Application by Highways England for a Development Consent Order in relation to the A30 Chiverton to Carland Cross Scheme.

The Examining Authority's first written questions and requests for information in relation to the dDCO

Issued on 13 February 2019

**Figure 2-1** The extent of the reaches covered by the habitat walkover survey (note 13.3 and 16.1 are stillwaters)

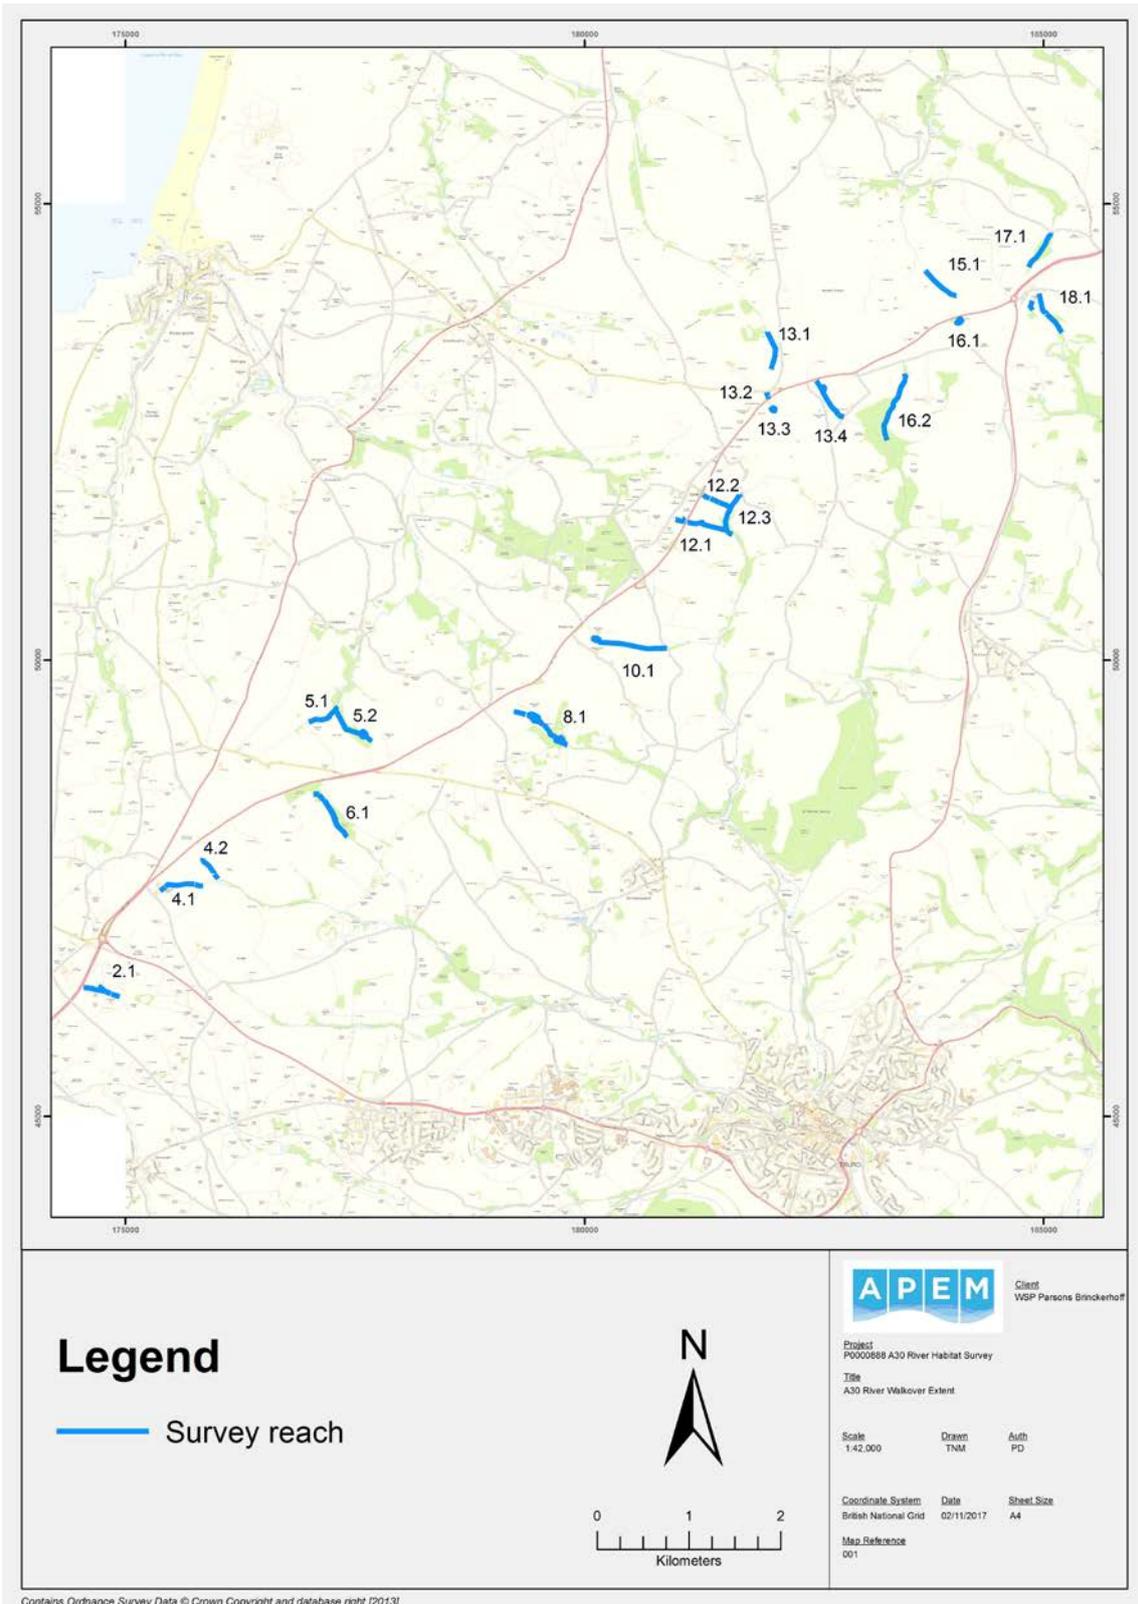
1.2.1	Applicant	<p>It is noted that the River Habitat Appraisal was carried out in November/December 2016.</p> <p>a) Can you confirm if there has been any update to the appraisal?</p> <p>b) If not, can you explain what confidence you have in the findings and the extent to which it remains appropriate to inform the assessment?</p>
